Your Ref: OWPC22156
Our Ref: LU/91/19/PL 21-03-2019
Please ask for:
Andrew Wood

Change of use of parts of seafront for temporary food & drink outlets & other seaside uses together with associated temporary/portable structures & equipment for use by businesses associated with those outlets.

Various sites along Littlehampton Promenade Littlehampton

SITE LOCATION PLAN AND
BLOCK PLAN - SITE C&D

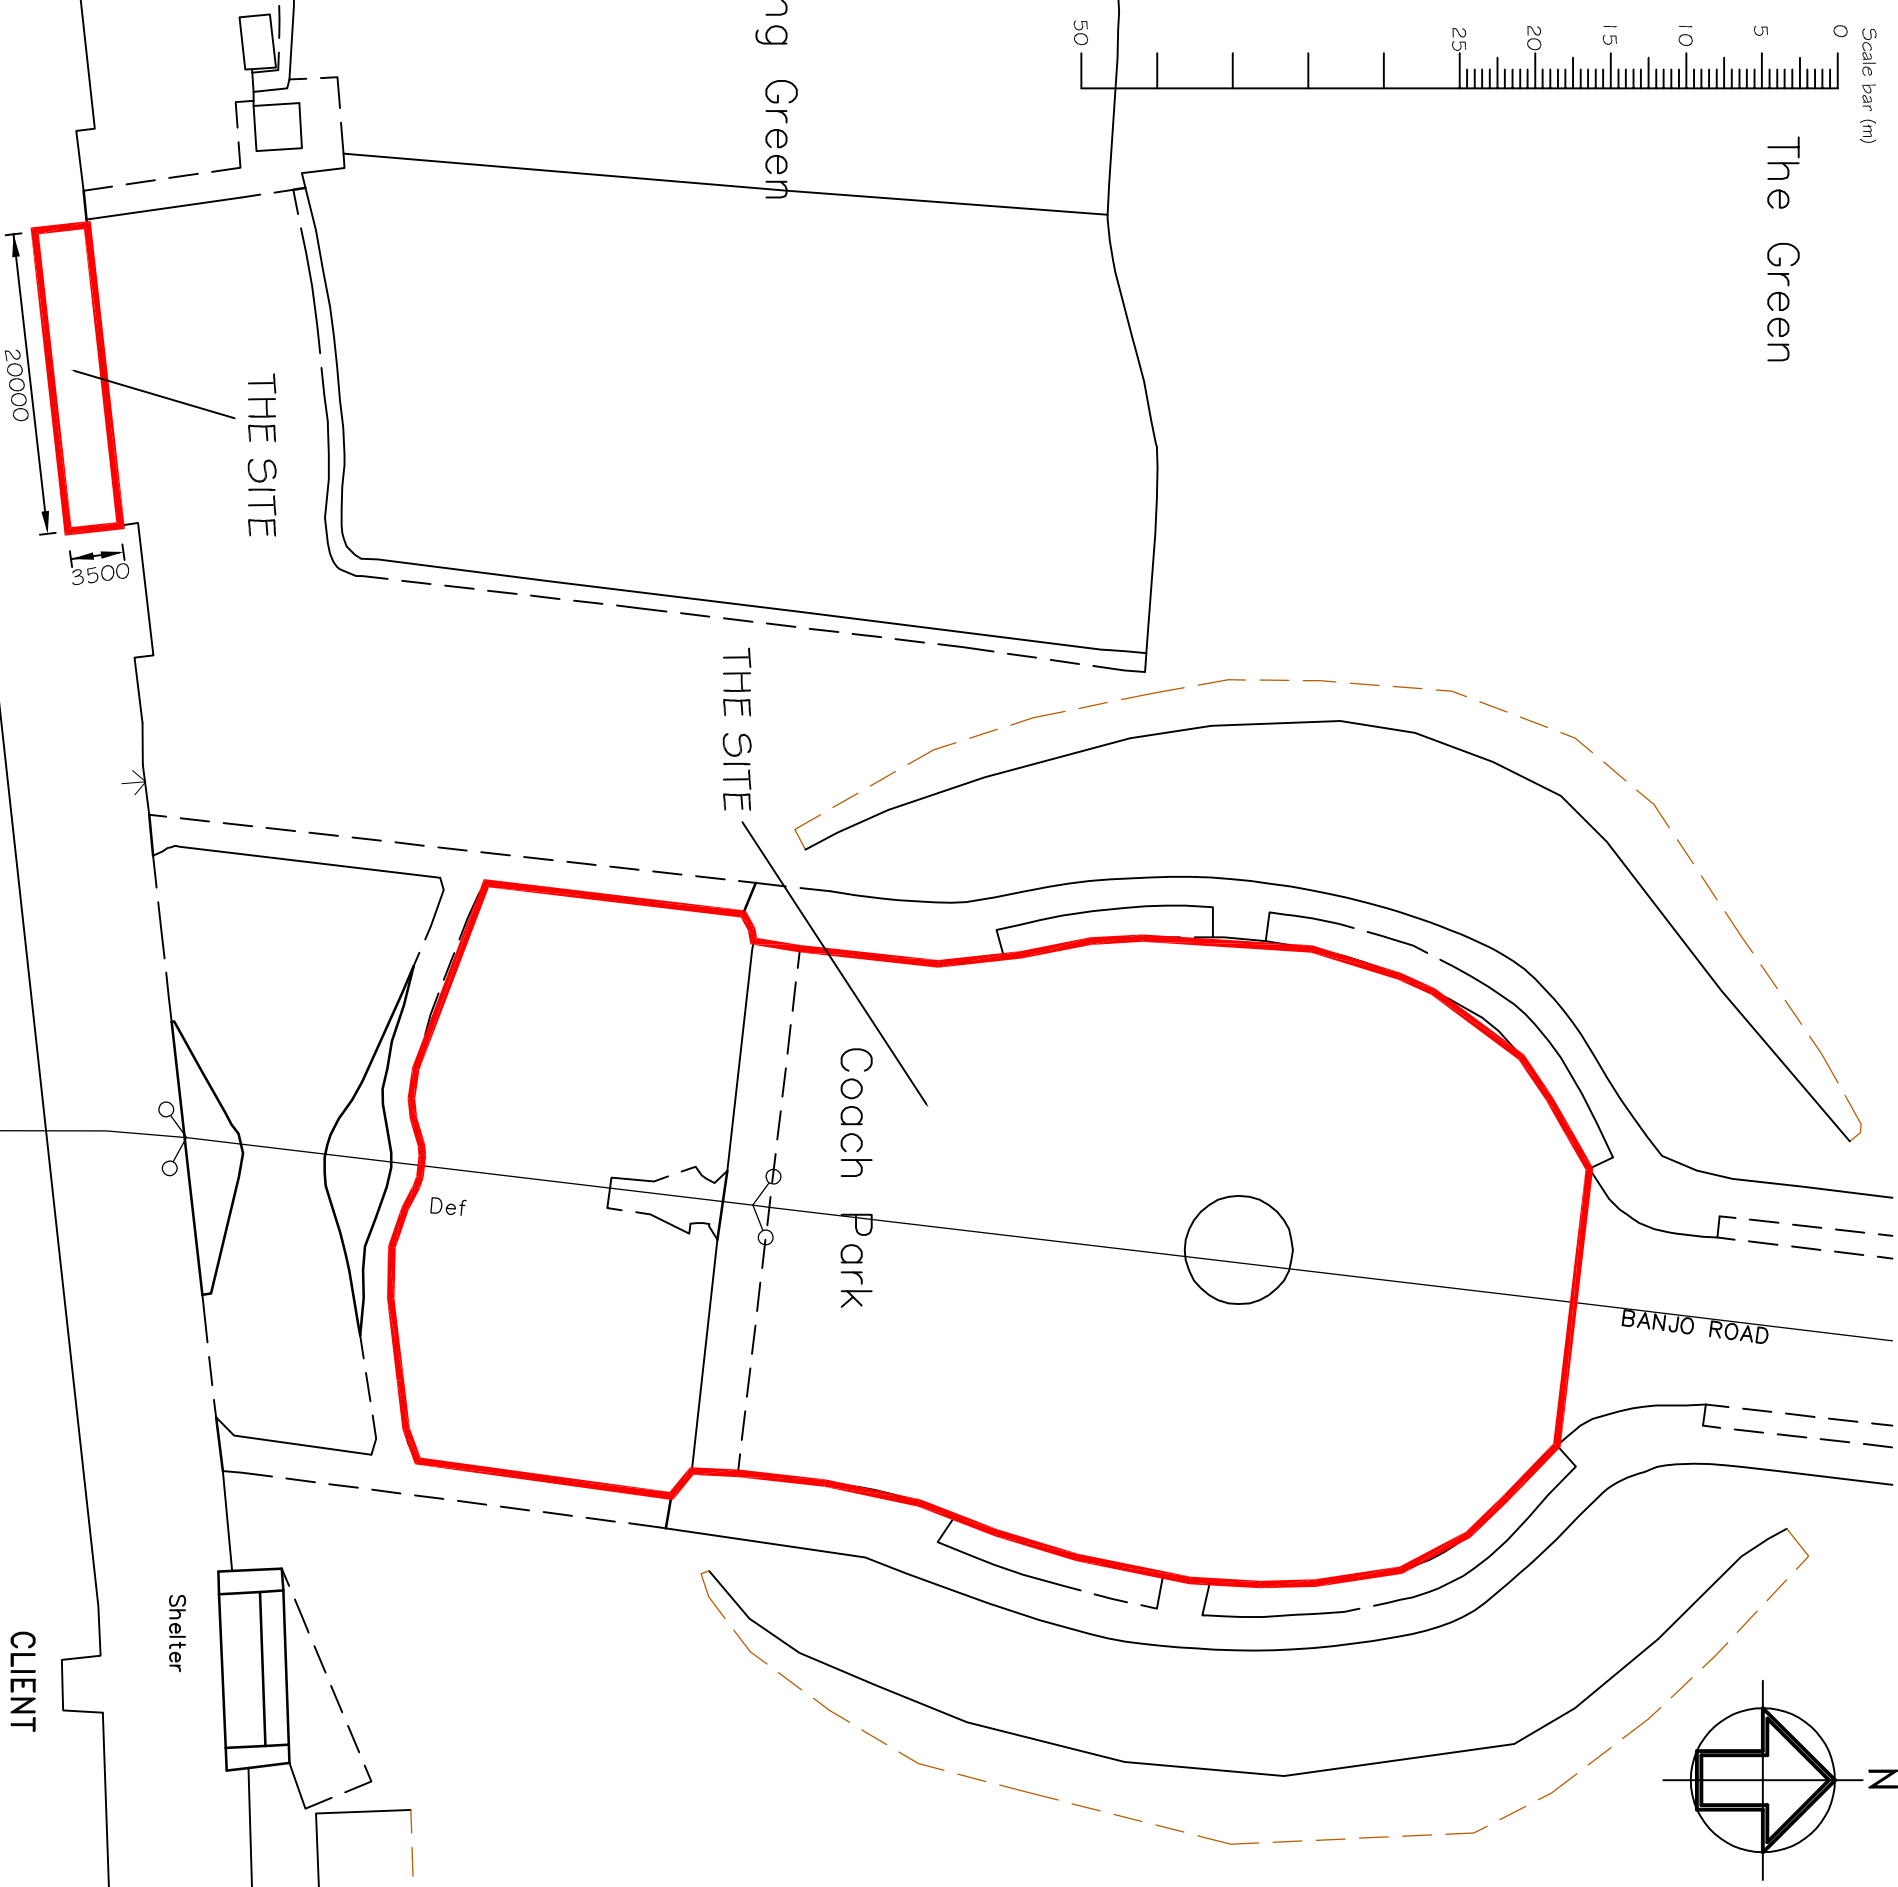
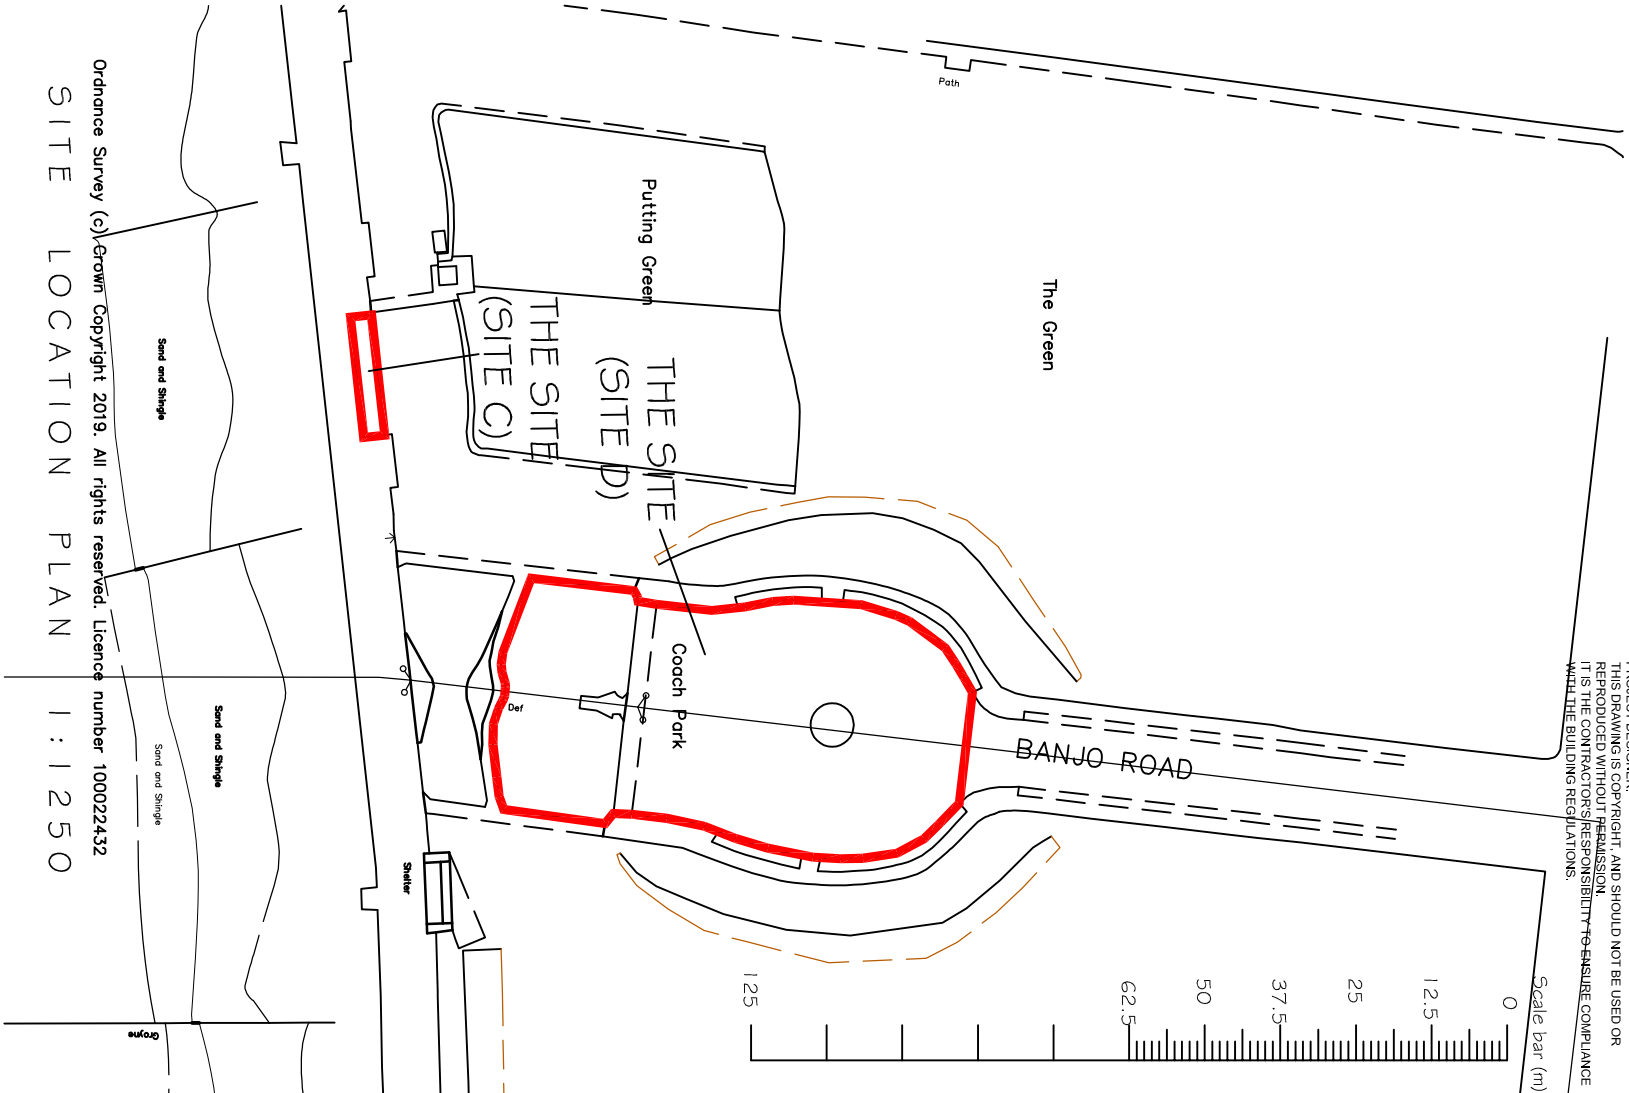
The Loss of the coach park will have a massive detrimental effect on all the local businesses in the area. The coach park allows for many tourists to be brought to the area, in a safer and more environmentally friendly way. Even on a quiet windy cold day, the coach park allows for the local business' to benefit from the tourists that have arrived on these pre arranged trips. Should coaches be unable to park, with the ease that they been used to over the previous years, they may find other resorts to visit with easier access.

Also trying to park coaches in the streets will cause major problems in an area we already struggle for parking during peak seasons.
